**Letter of objection to the Preferred Infrastructure Report for State significant infrastructure application SSI-9487 Inland Rail – Narromine to Narrabri**

1. We act for NSW Farmers in relation to the Narromine to Narrabri Project part of the Inland Rail Project (**N2N Project**) which is the subject of State significant infrastructure application SSI-9487 (**N2N SSI**).

The Australian Government is delivering Inland Rail through the Australian Rail Track Corporation (ARTC), in partnership with the private sector.

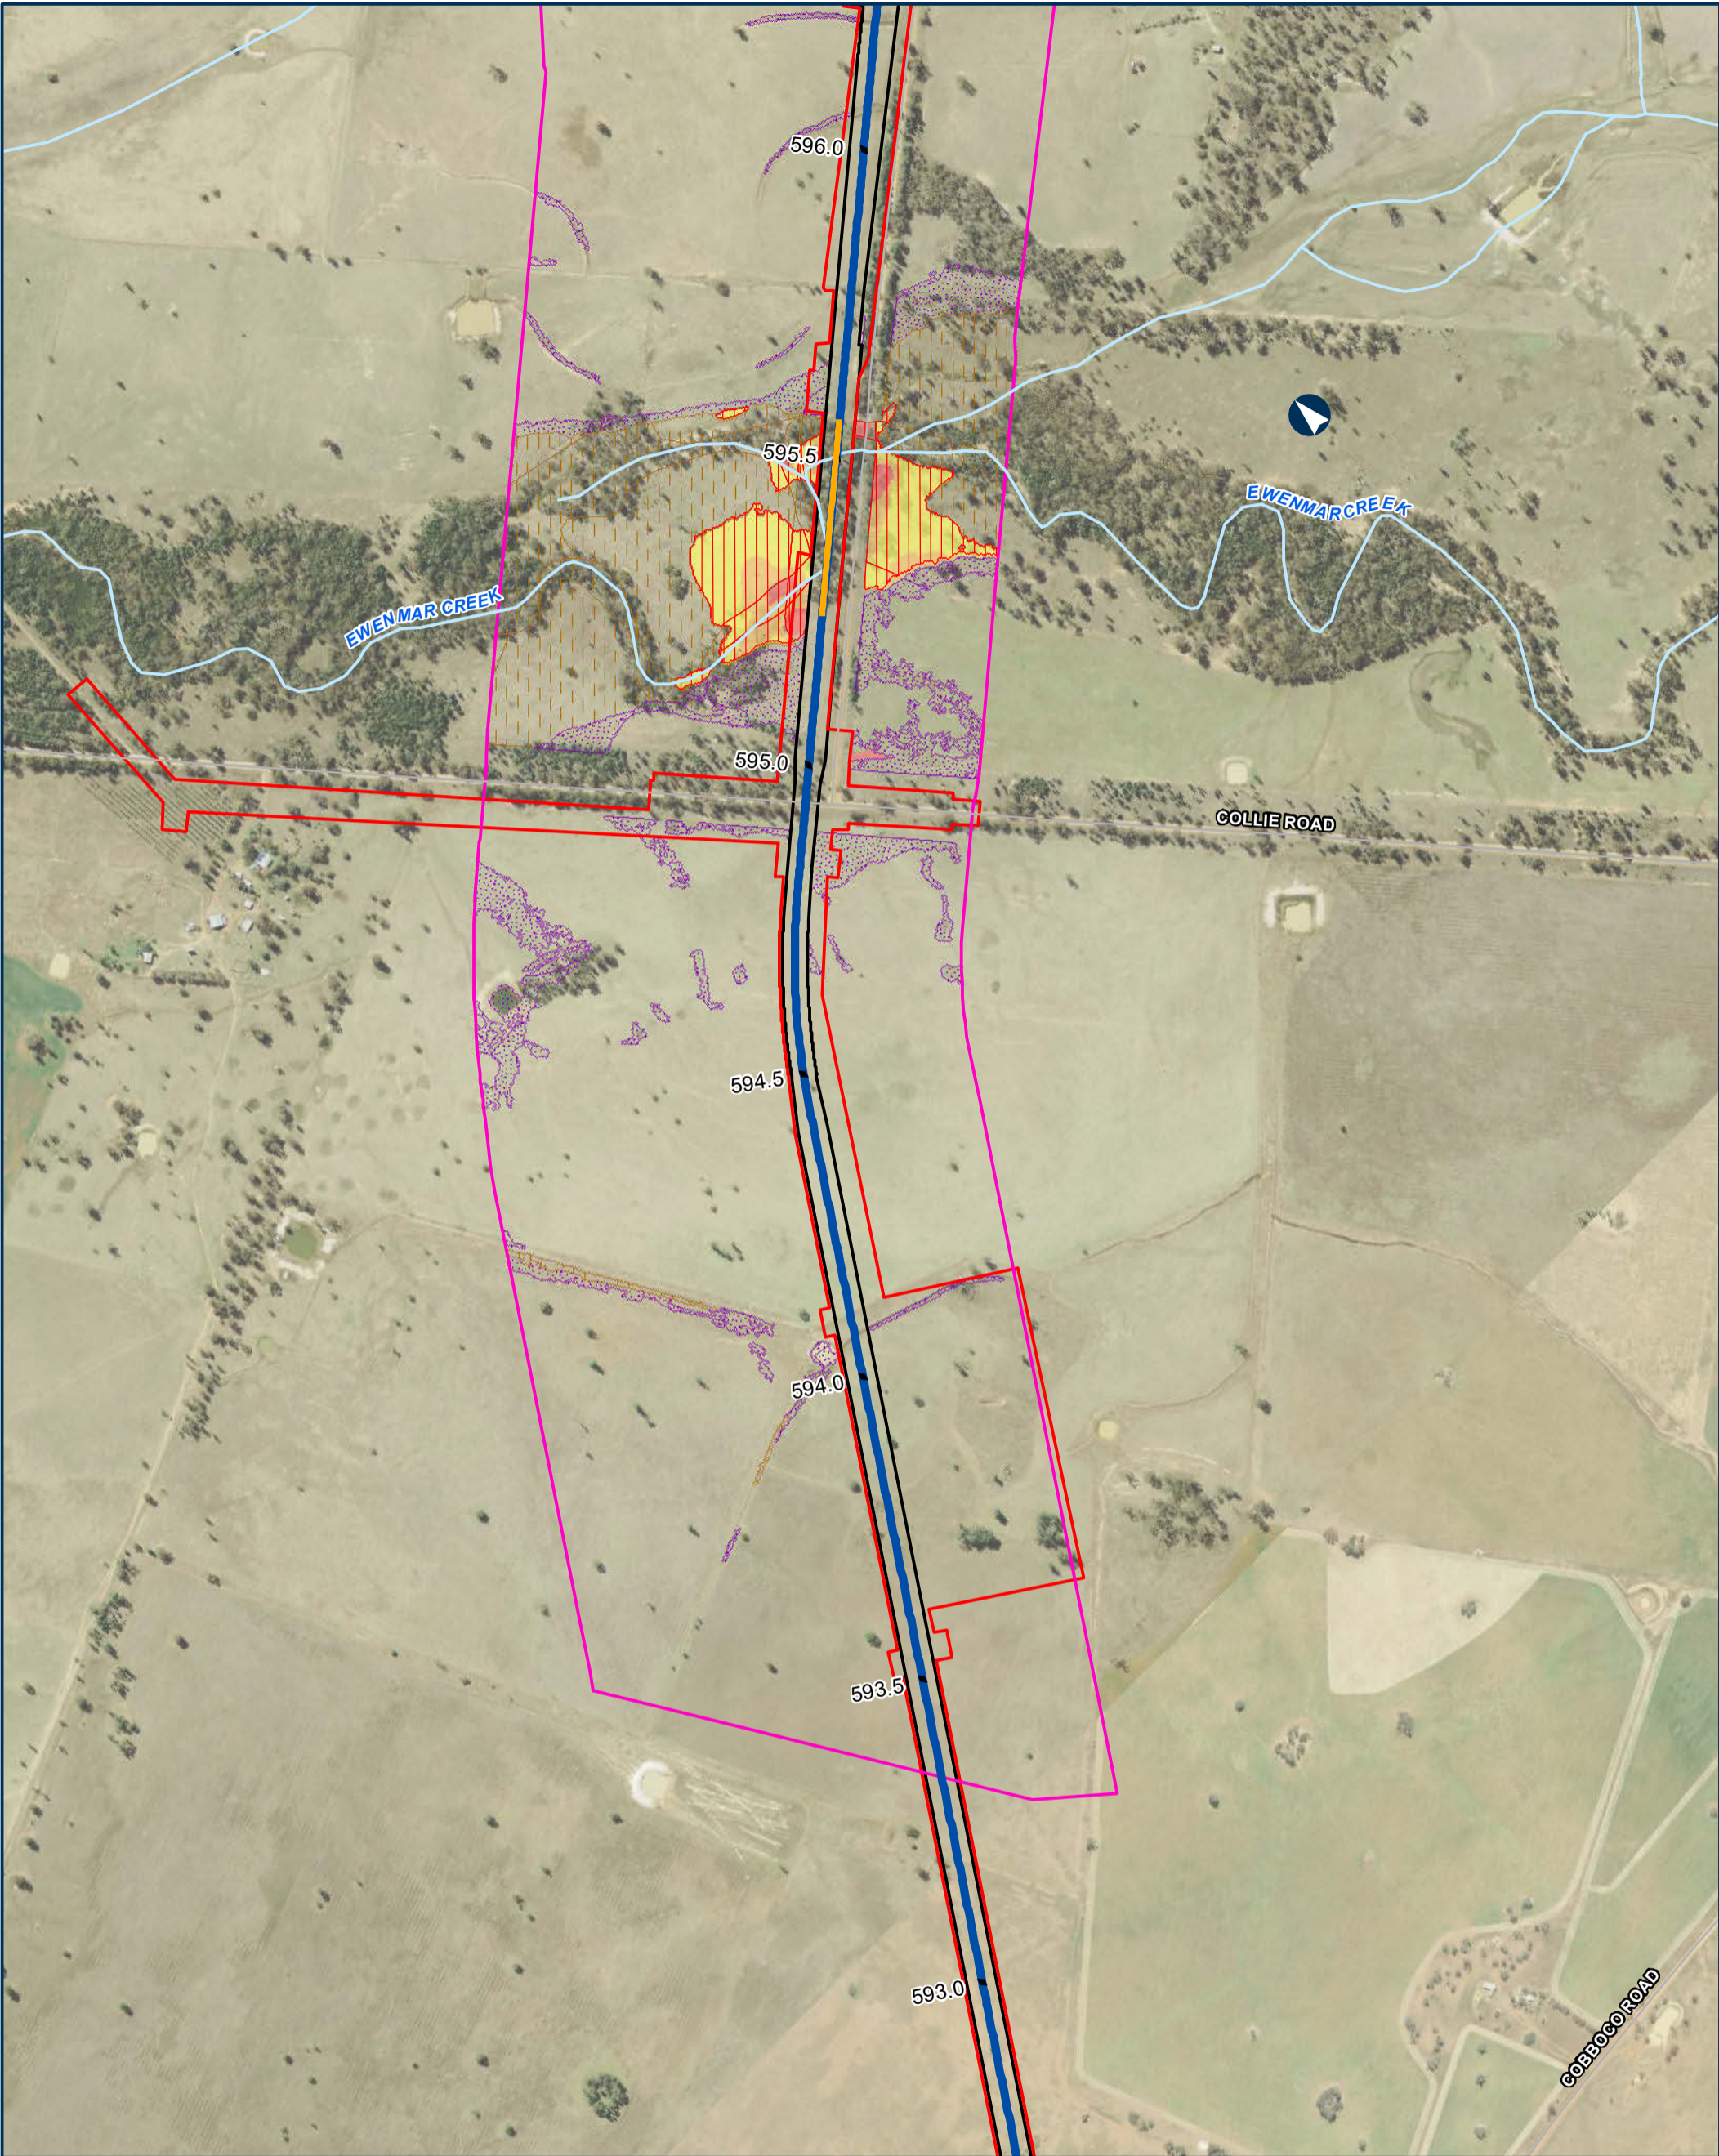
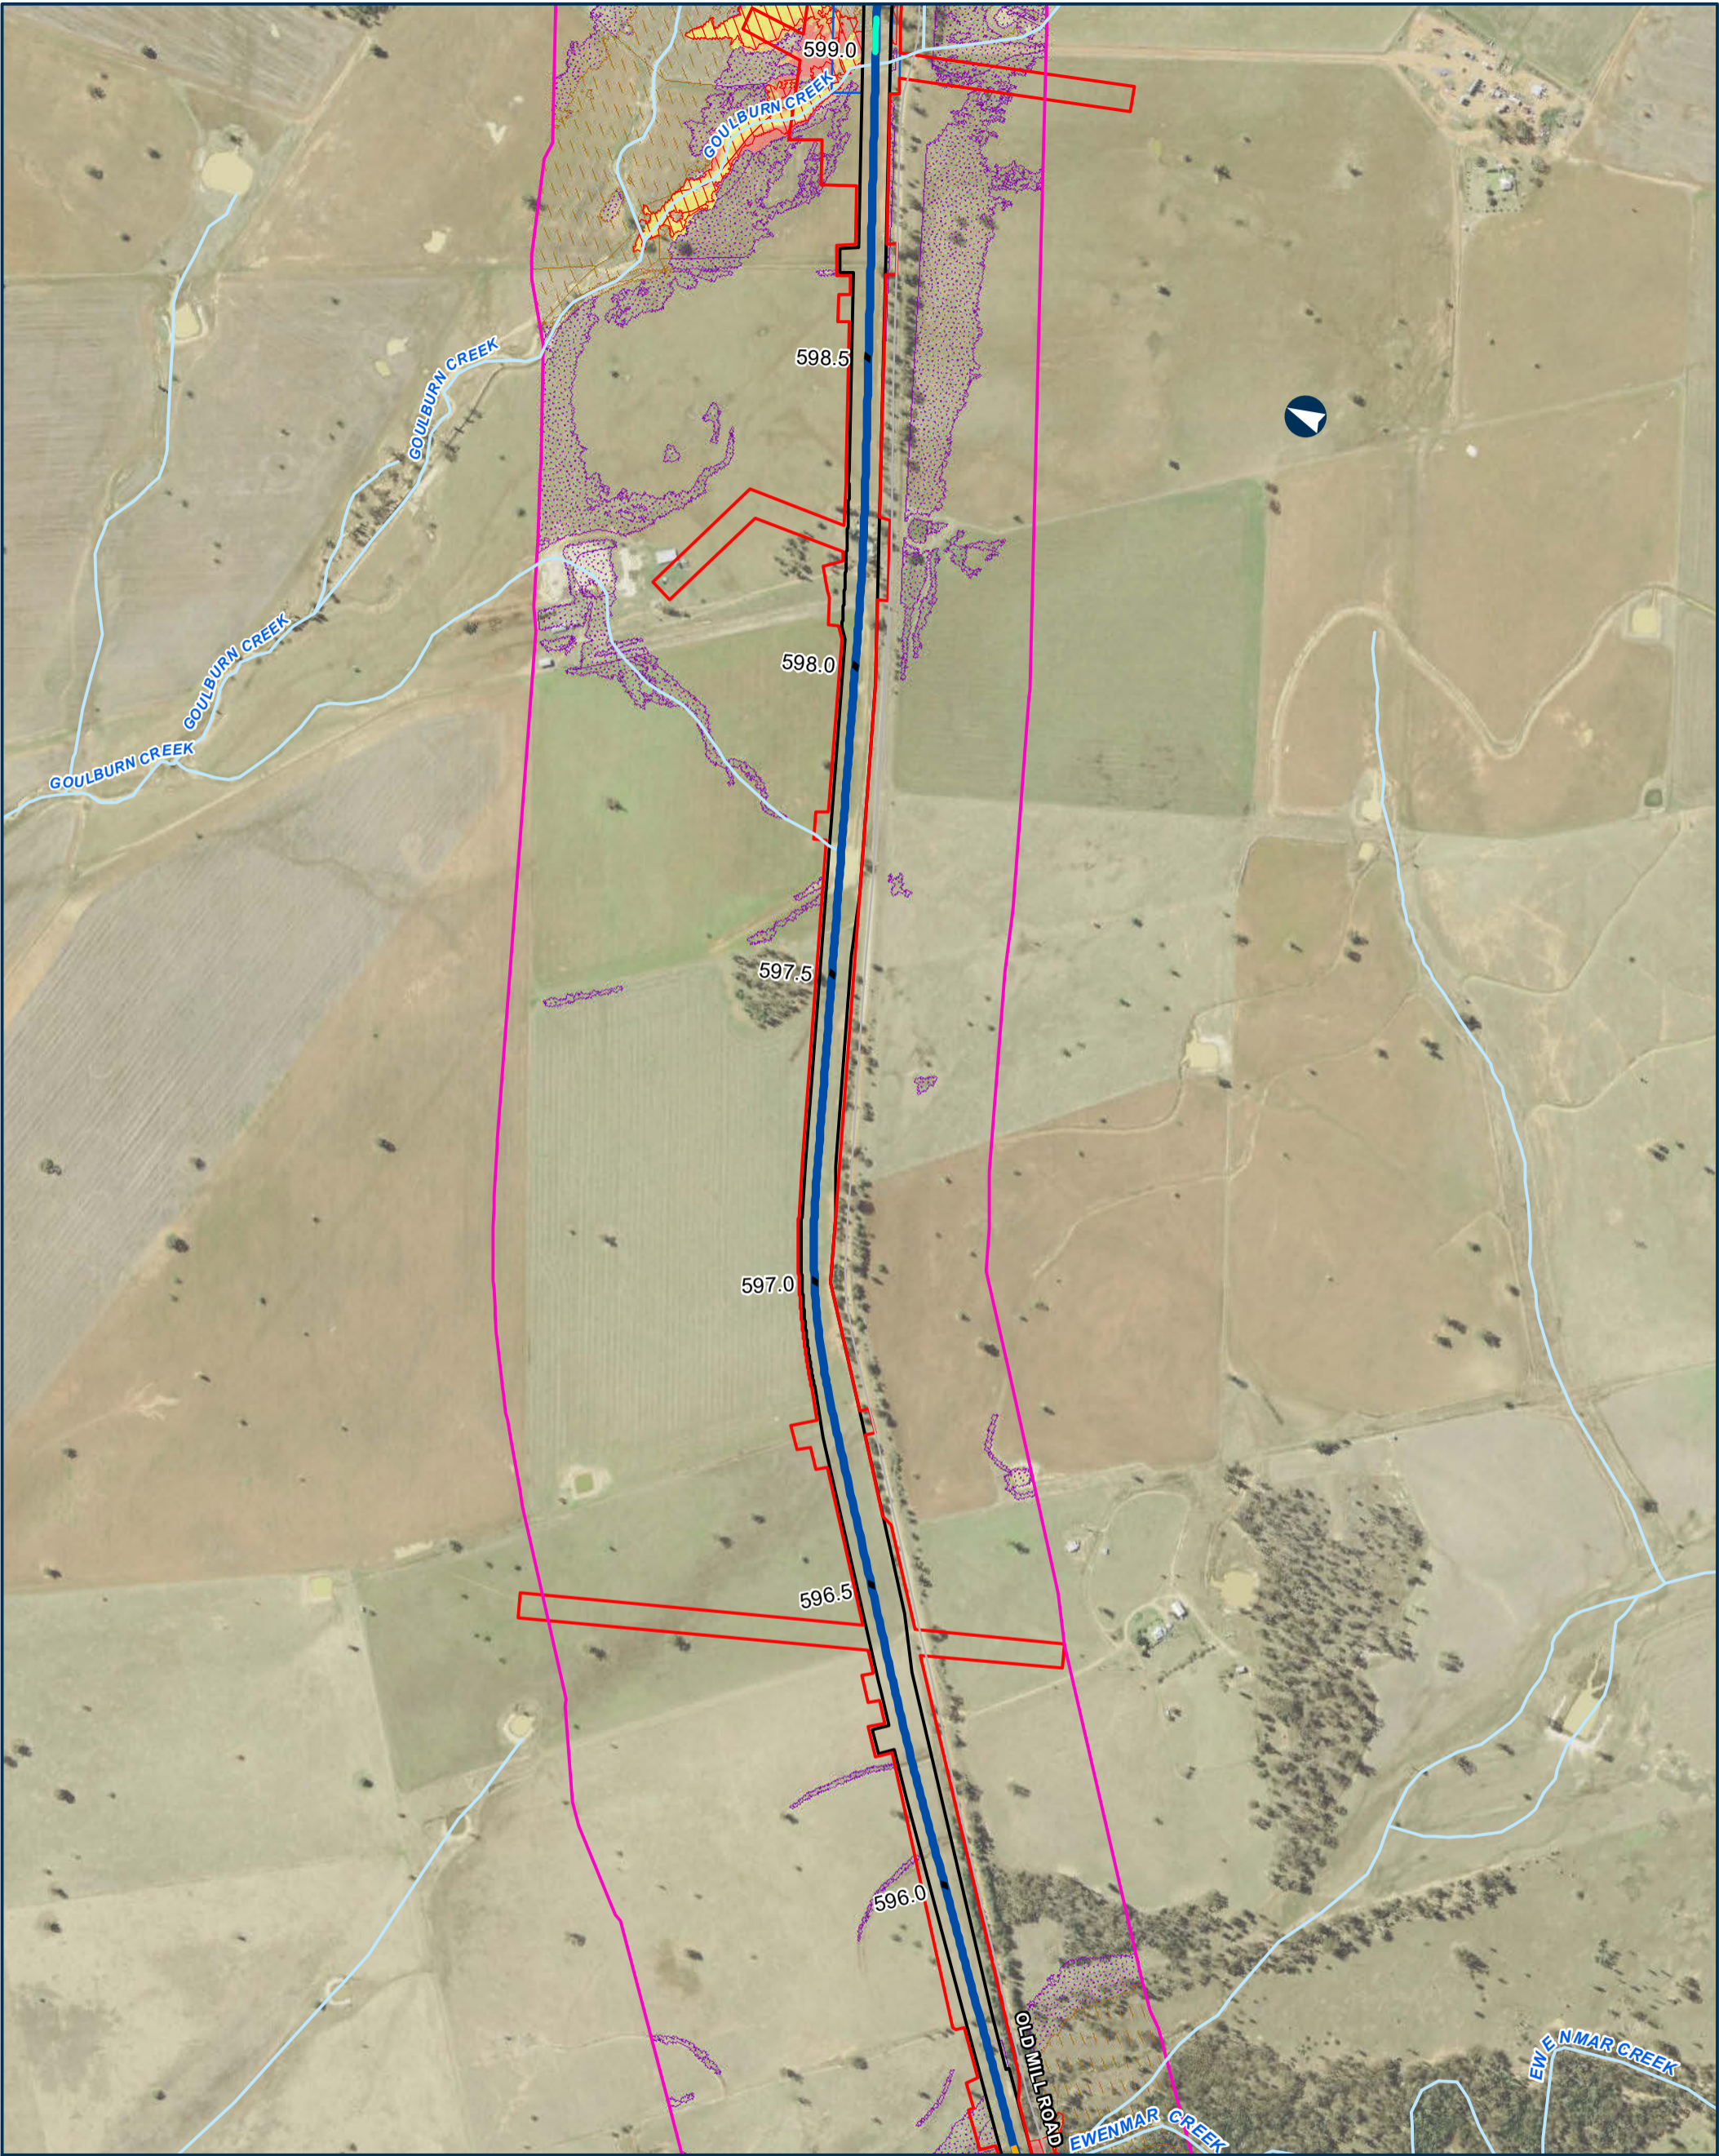
- 22.2 Concerns also remain about the impact of the construction of the rail line in the area of the **Warrumbungles Watershed**. Some identification of quantitative design limits (QDLs) to ensure that velocities do not exceed the speed where water could potentially cause scouring but without detailed design there are still concern that even if the velocities can be managed within acceptable parameters fundamentally those structures are converting sheet flows into channel flow and changes to the nature of flows beyond land owned by ARTC cannot be authorised without an easement granted by the landowner.
